Subject: FW: FP/127/15/DOC 114 Felpham way

From: Thomas Callaway
Sent: 12 August 2015 16:24
To: Richard Temple
Subject: RE: FP/127/15/DOC 114 Felpham way (2)

Proprietary Infiltration Crate Soakaway garden locations

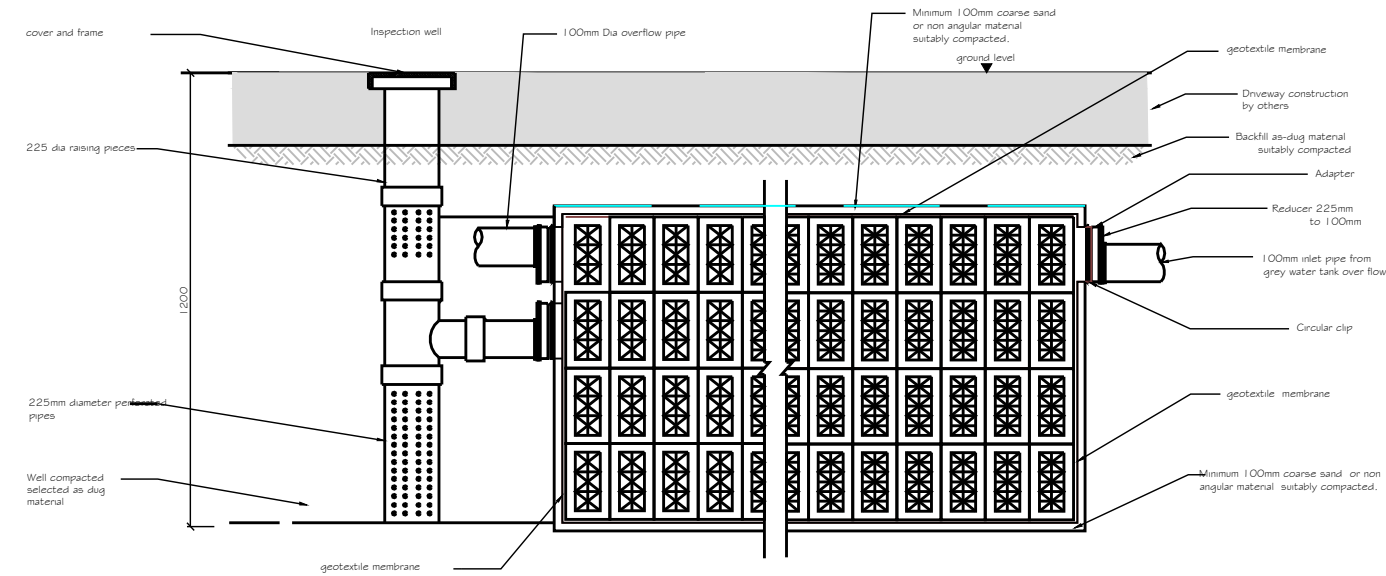
I would suggest that approximately equal soakaway storage is provided on both sides of the roof ridge. Perhaps crate soakaways (dimension 2x1x0.8m) are used in both gardens, linked to the rainwater harvesting etc by overflows; and that a further two of the same dimensions are positioned on the other side of the building. The base of the soakaways should be no lower than 1.2m below ground level, and it would be useful to have some kind of construction drawings for the surface water drainage system, including the permeable paved areas. It may be sensible to have high level overflows from the soakaways to each other and also the permeable paved areas.

Title
Site Plan

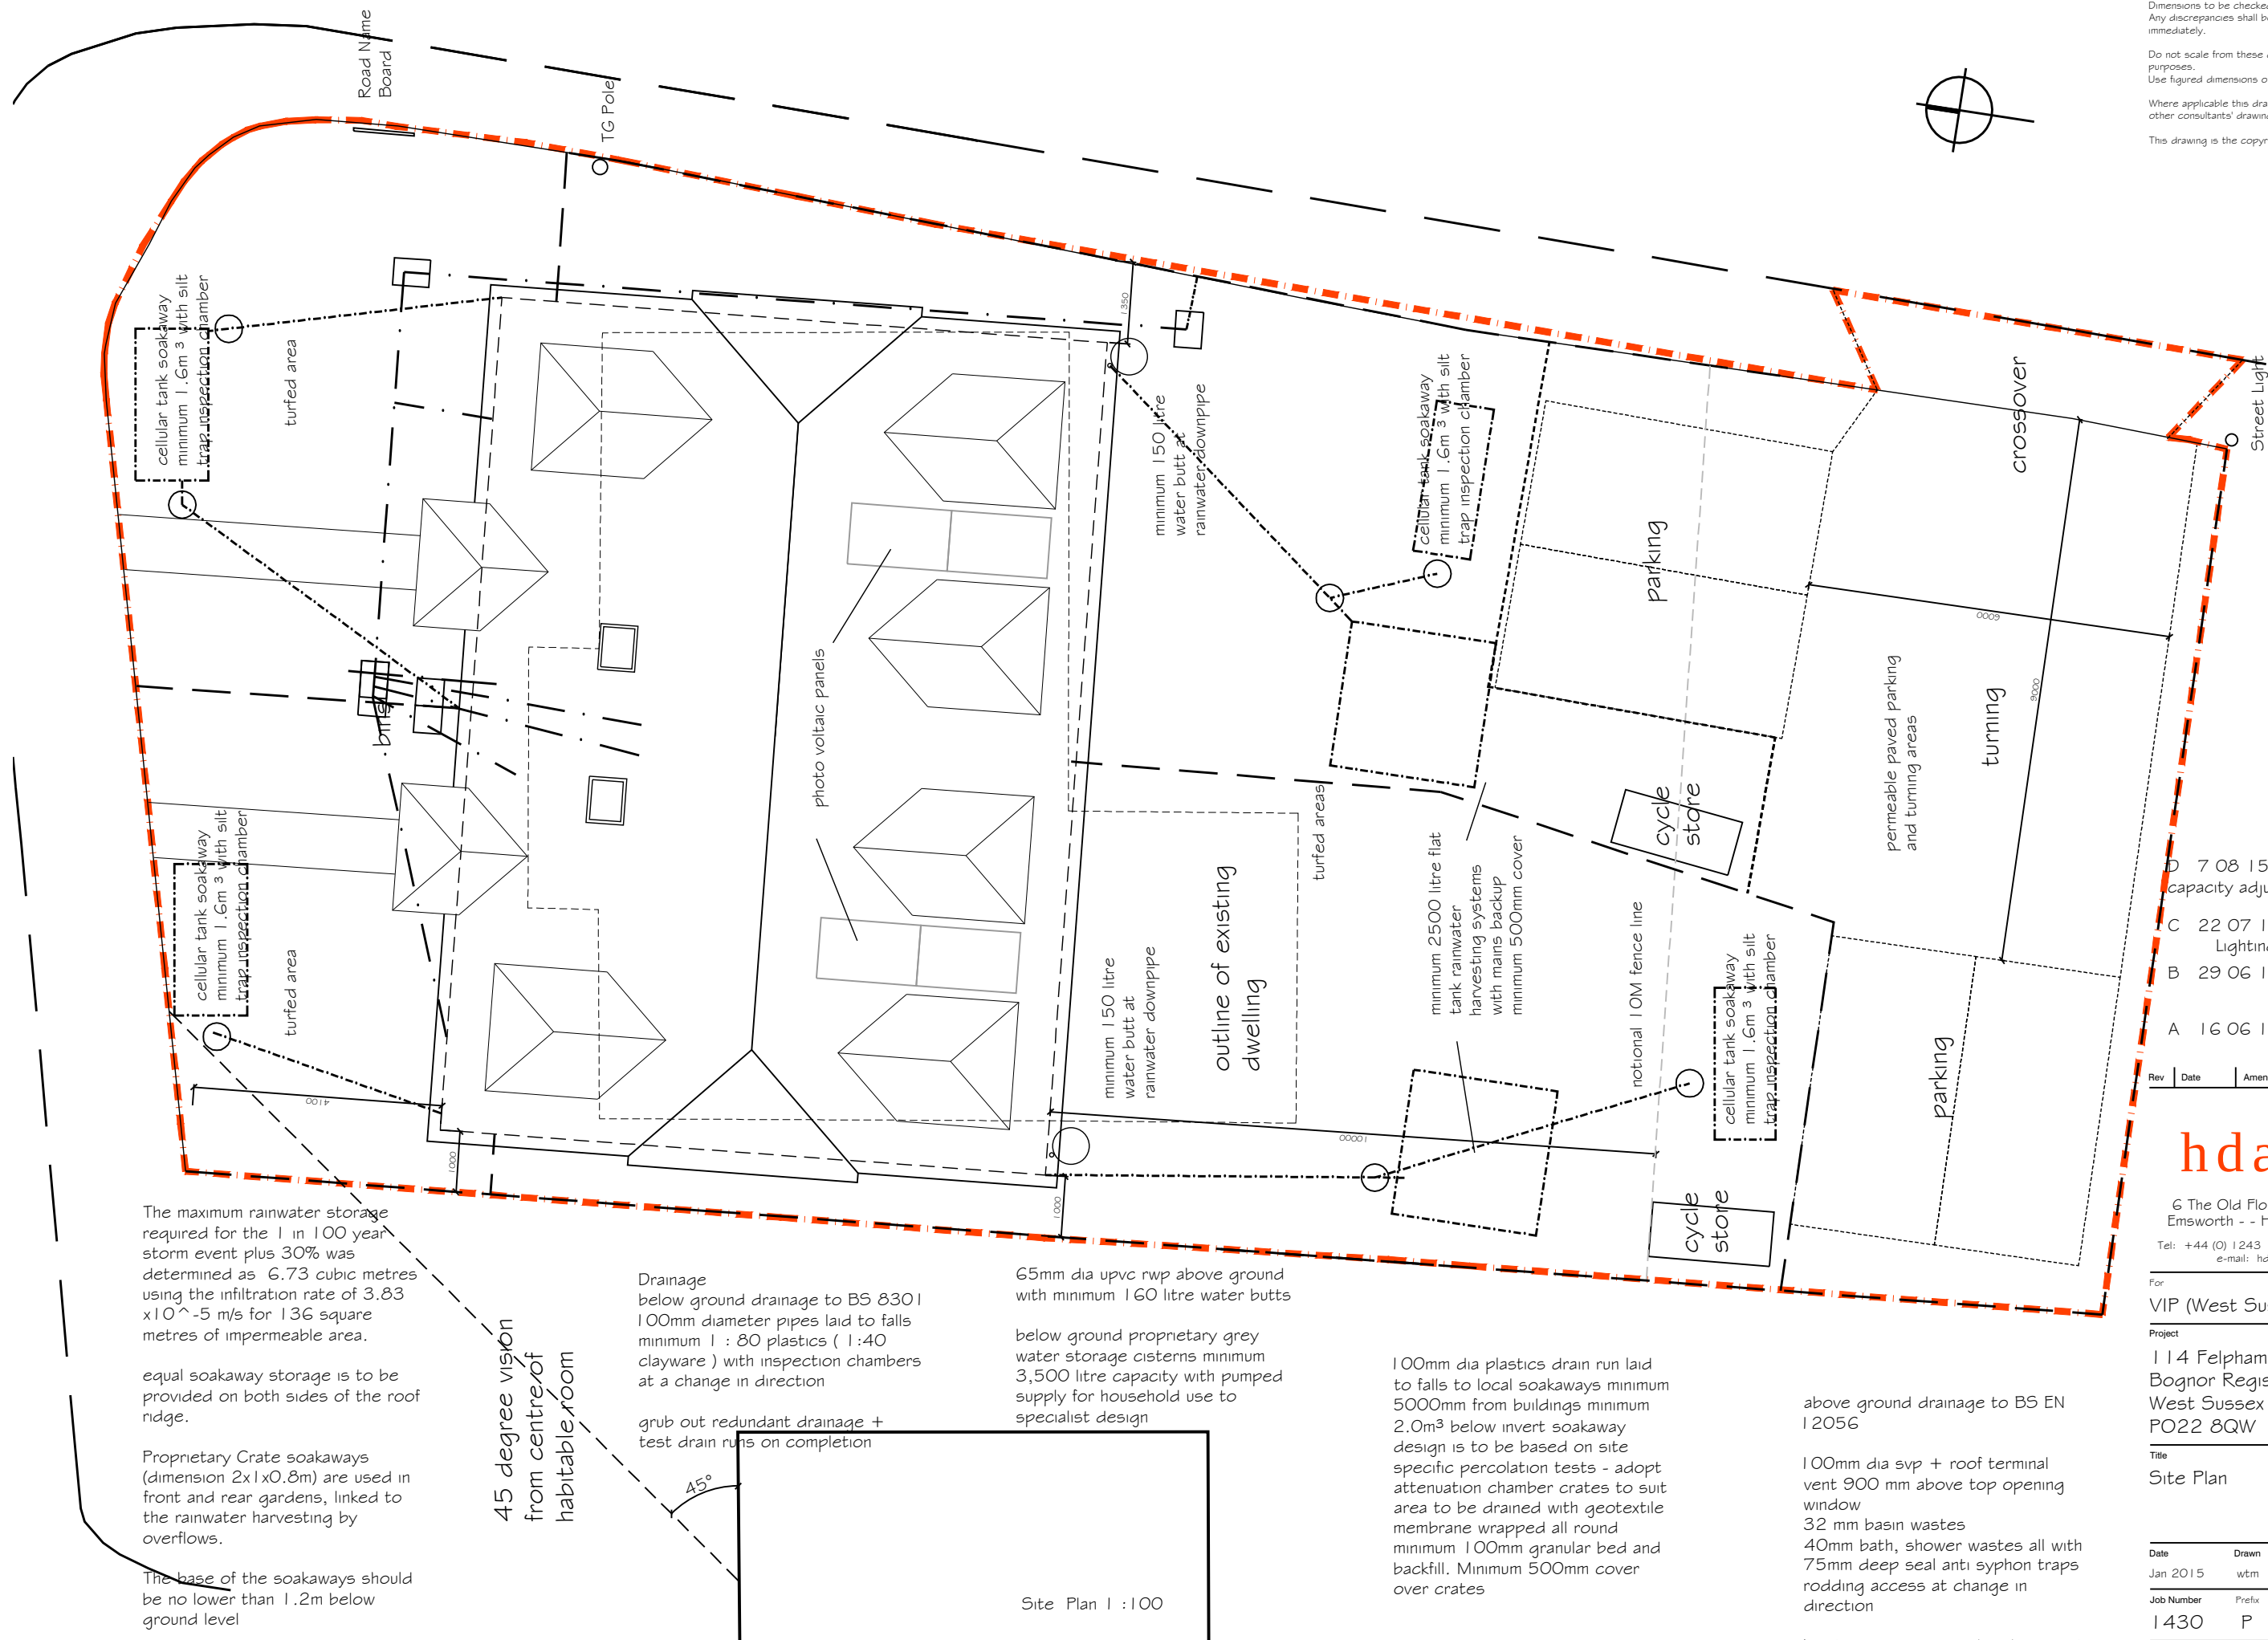
I found the rest of the calculations quite confusing to follow so applied the raw data to a spreadsheet I have put together to come up with some design figures. Please note I am not willing to distribute the spreadsheet in case of any inaccuracies that could lead to liability issues. The maximum storage required for the 1 in 100 year storm event plus 30% came out at 6.73 cubic metres using the infiltration rate of 3.83×10^{-5} m/s for 136 square metres of impermeable area.
